Attachment 3: Responses to Issues Raised in Submission from Office of Environment & Heritage to the Department of Planning (20 December 2018)

Sydney Opera House Trust
GPO Box 4274 Sydney NSW Australia 2001
Phone: +61 2 9250 7541
email: info@sydneyoperahouse.com
© Sydney Opera House Trust
Location: Drawing No: 49-BR-ARM01 Sheet: DA5126 Rev: D B1

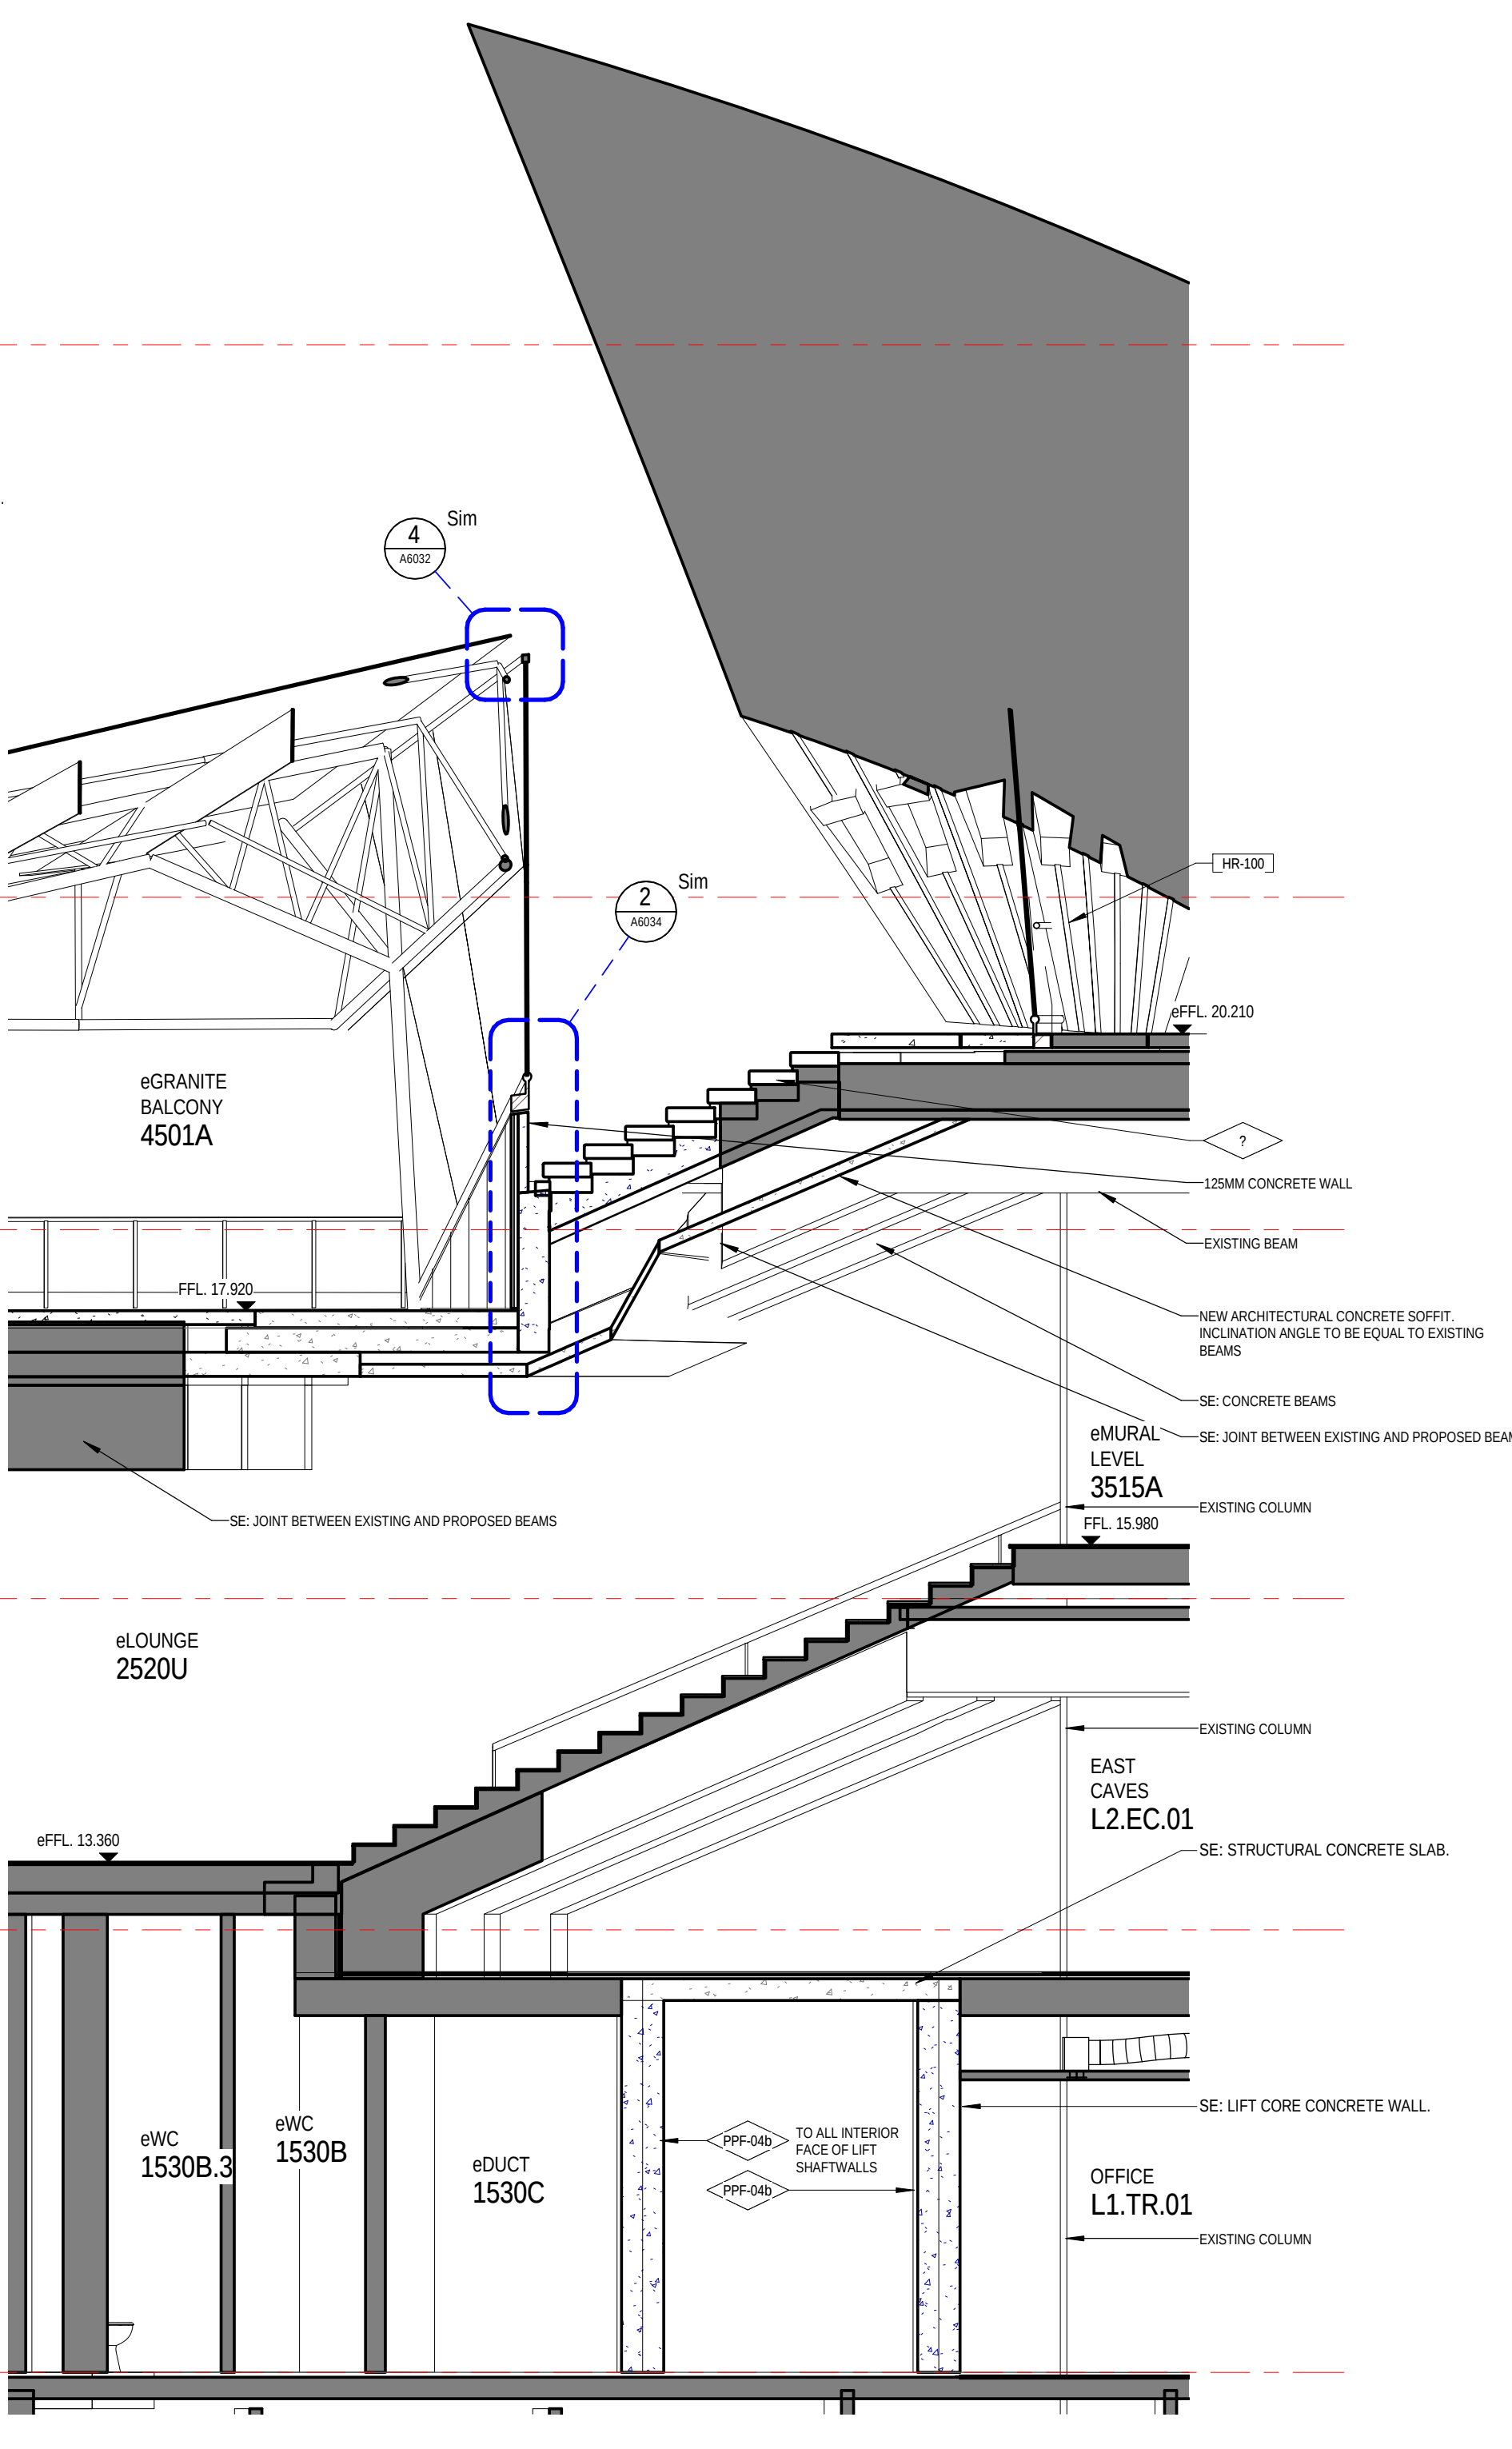
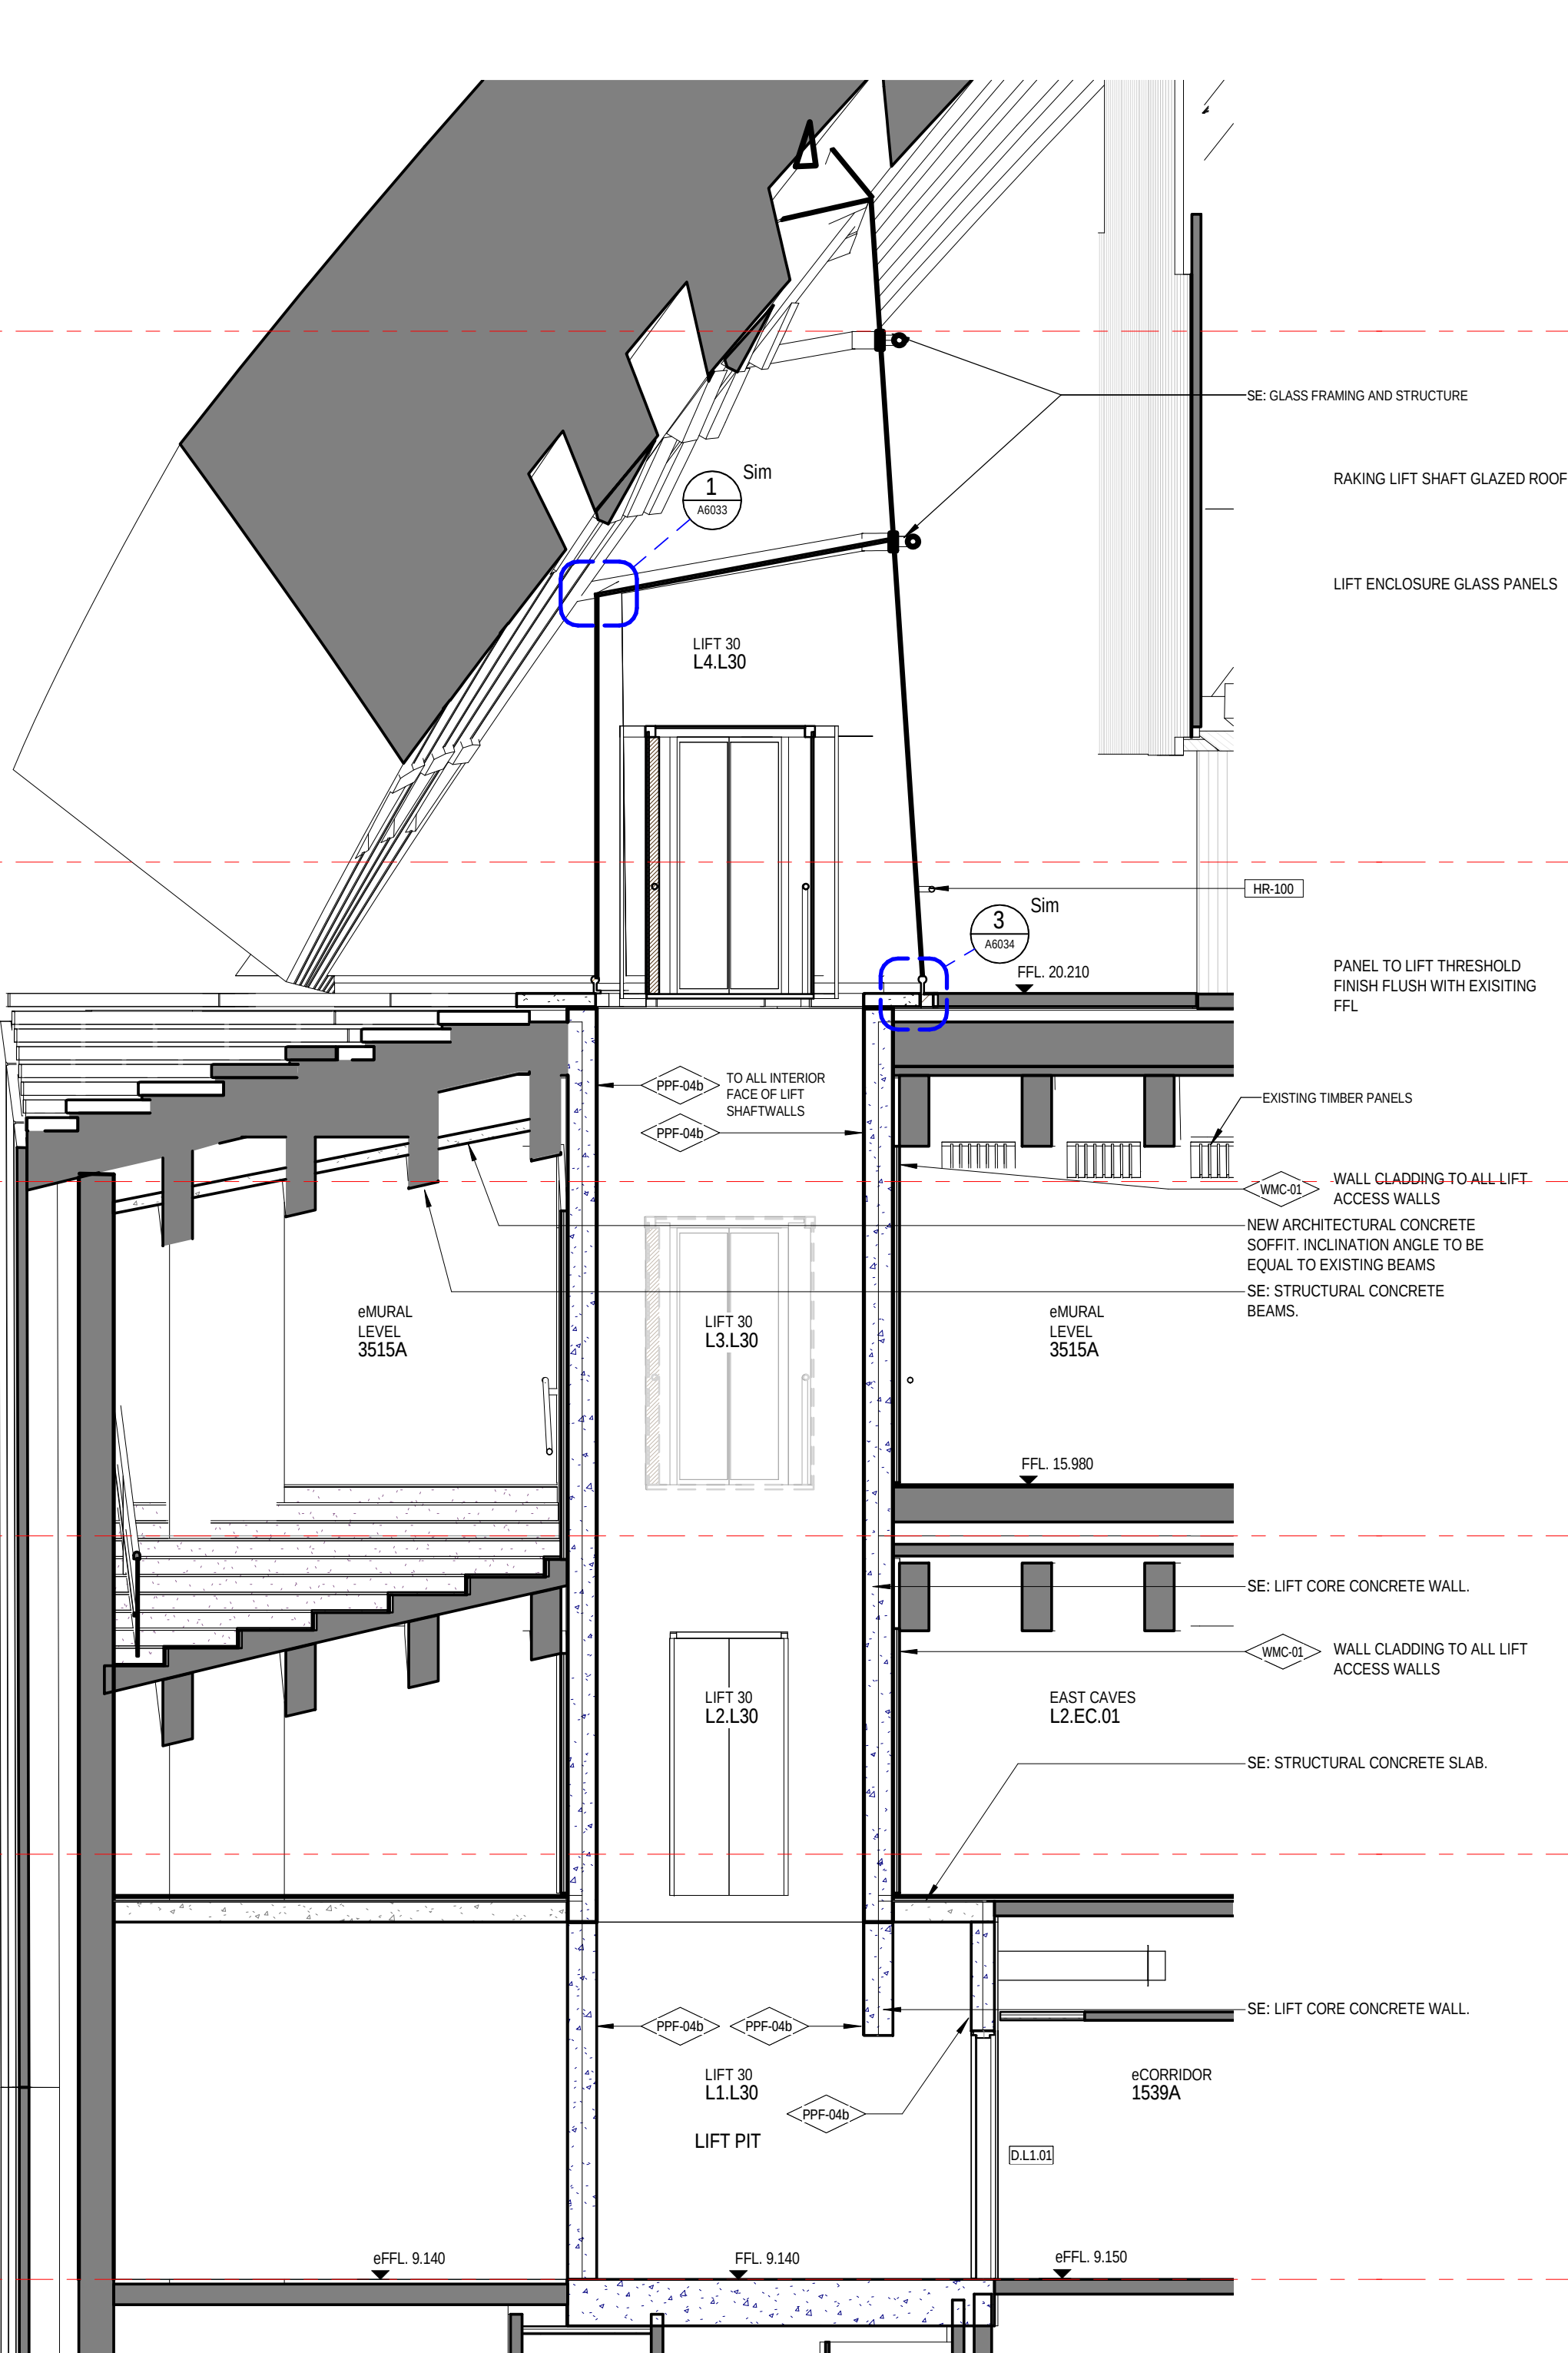
<p>4. Any archaeological impacts relating to lift base installations should identify the methodology for excavation, and include monitoring of the excavation by an archaeologist, recording of anything uncovered and the retention of as much as possible in-situ. This will ensure the proactive management and acknowledgement of any significant archaeology.</p>	<p>The construction of Lifts 29 and 30 in the Concert Hall Northern Foyer does not require any excavation below the existing floor level of Level 1 of the Sydney Opera House. This is shown in the vertical section plans of the lifts on drawings 49-BR-ARM01 Sheets DA5115 and DA5126.</p> <p>These lifts are similar to Lift 31 recently completed in the JST Northern Foyer. The lowest point of construction for this lift is Level 1, where the lift pit is situated. These lifts are quite distinct from new Lift 36 in the JST Southern Foyer (under construction) which requires excavation below Ground Level.</p>	<p>Plans DA5115 & DA5126</p>
